SY 18-00019

SHORELINE EXEMPTION PERMITTING

Project:
ROMANS RESIDENCE
12180 TEANAWAY RD NE
CLE ELUM, WA 98922

RE: SX-18-00019 Romans Shoreline Exemption – Request for additional information

SITE PLAN

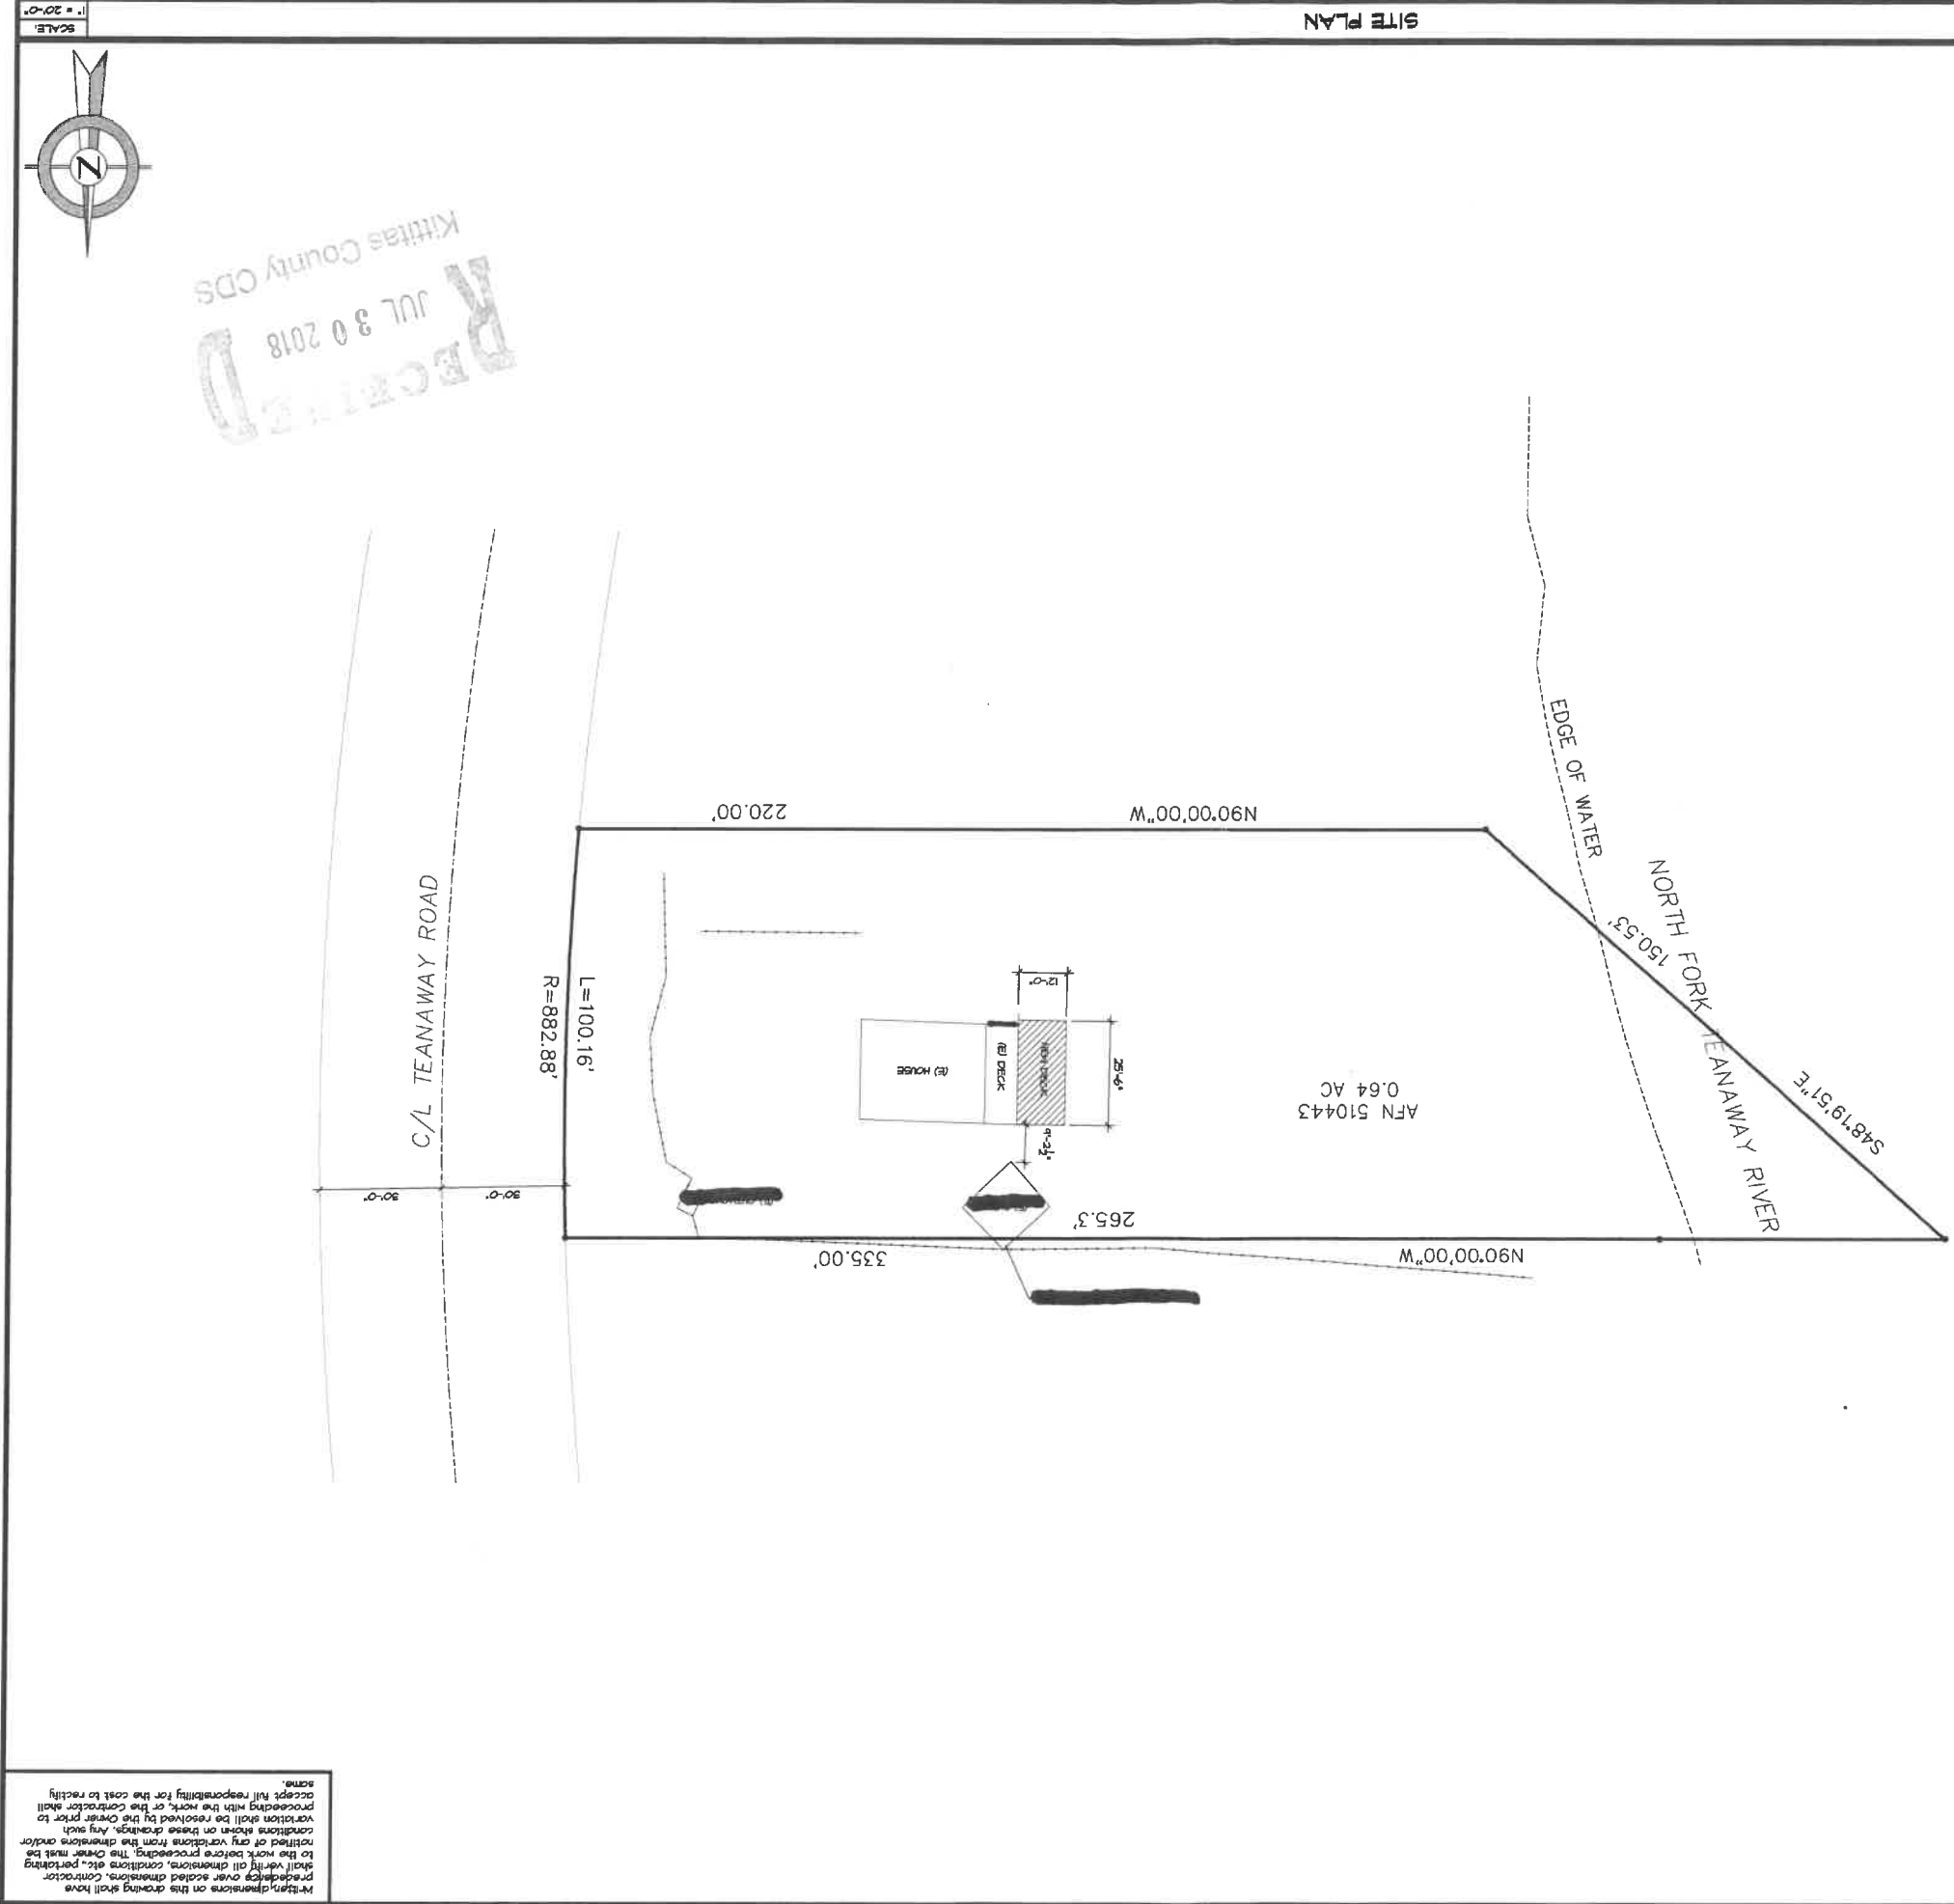
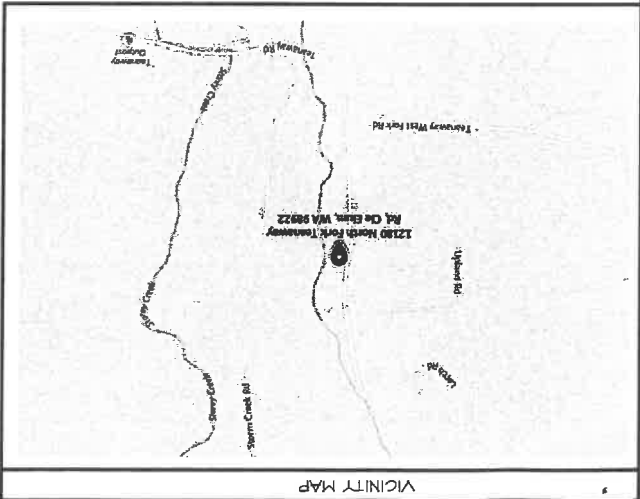
- 1) Access to the property must be noted on the site plan.
- 2) All legal setbacks must be indicated on the site plan.
- 3) Any well or septic systems (and related drainfields) must be represented on the site plan.
- 4) The site plan indicates the project is 130' from the "edge of water." Shoreline exemption review requires a precise distance from the Ordinary High Water Mark (OHWM). Please indicate this distance on the site plan.

Please submit an amended site plan demonstrating the items listed above. CDS will review and process your application once this is clarified.
